Sent: 26 January 2012 09:14
To: Planning
Subject: Planning application N6/2011/2643/AD - Stanborough Beefeater

District ref: N6/2011/2643/AD
HCC ref: WH/7/2012
HCC received: 05/01/2012
Area manager: James Dale
Case officer: Lindsey Lucas

Stanborough Beefeater
Stanborough Road
Welwyn Garden City
AL8 6DQ

Erection of illuminated totem sign

Stanborough, Stanborough Road  
 Welwyn Garden City  
 Hertfordshire  
 AL8 6DQ

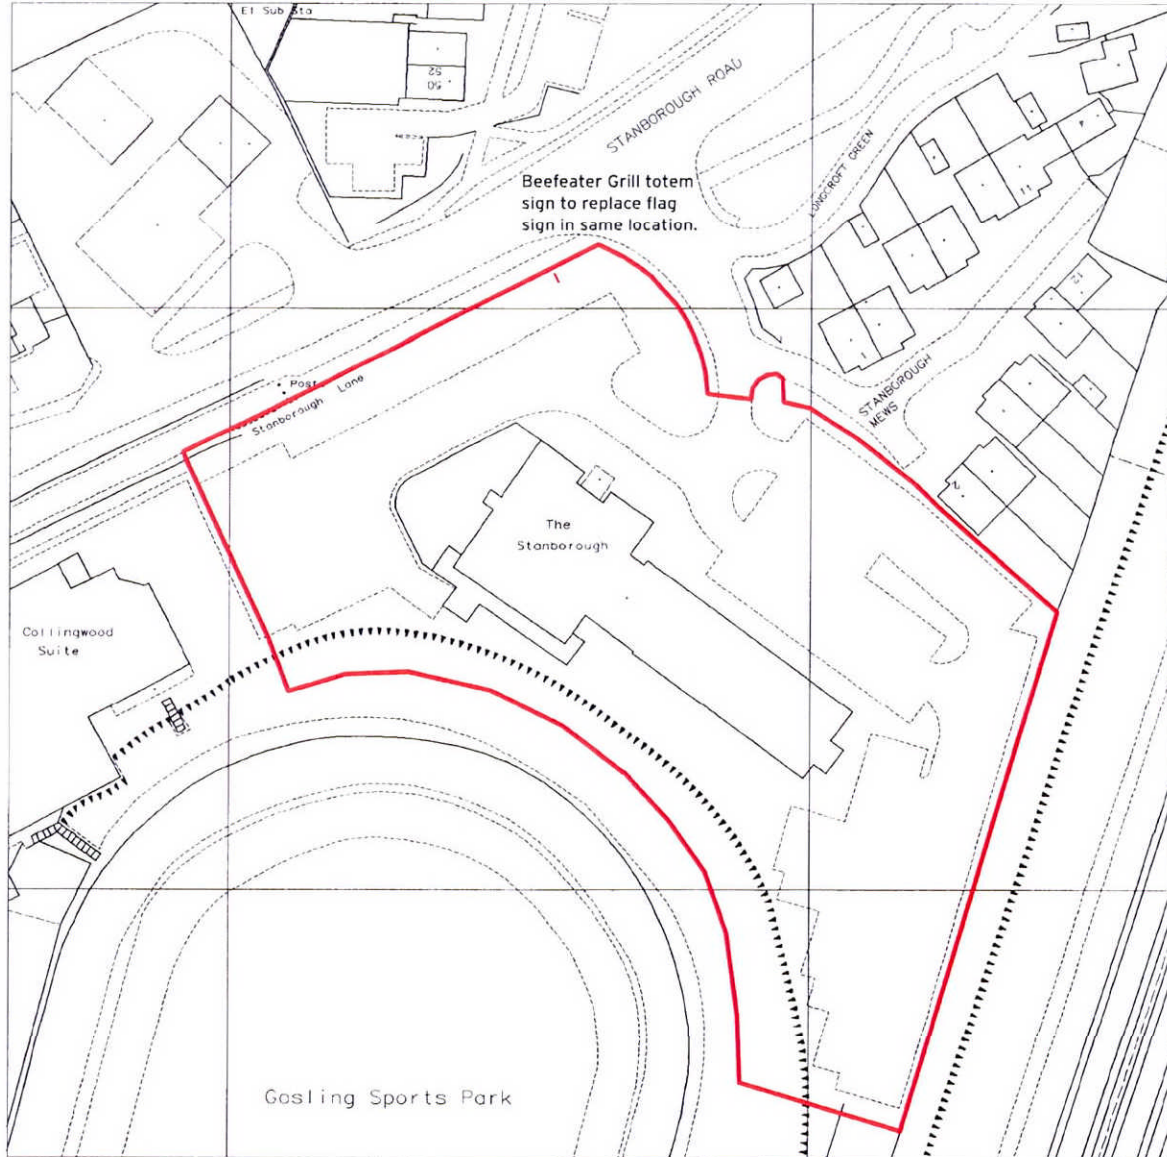
I am advised that the extent of public highway includes approximately 2m of the verge behind the combined cycleway/footway. Therefore the sign is located within the public highway and therefore cannot be condoned.

Nevertheless I acknowledge that land ownership is not an issue that has a bearing on consideration of the planning application and as there are no technical reasons to object to the sign a highway objection on encroachment grounds is not justified.
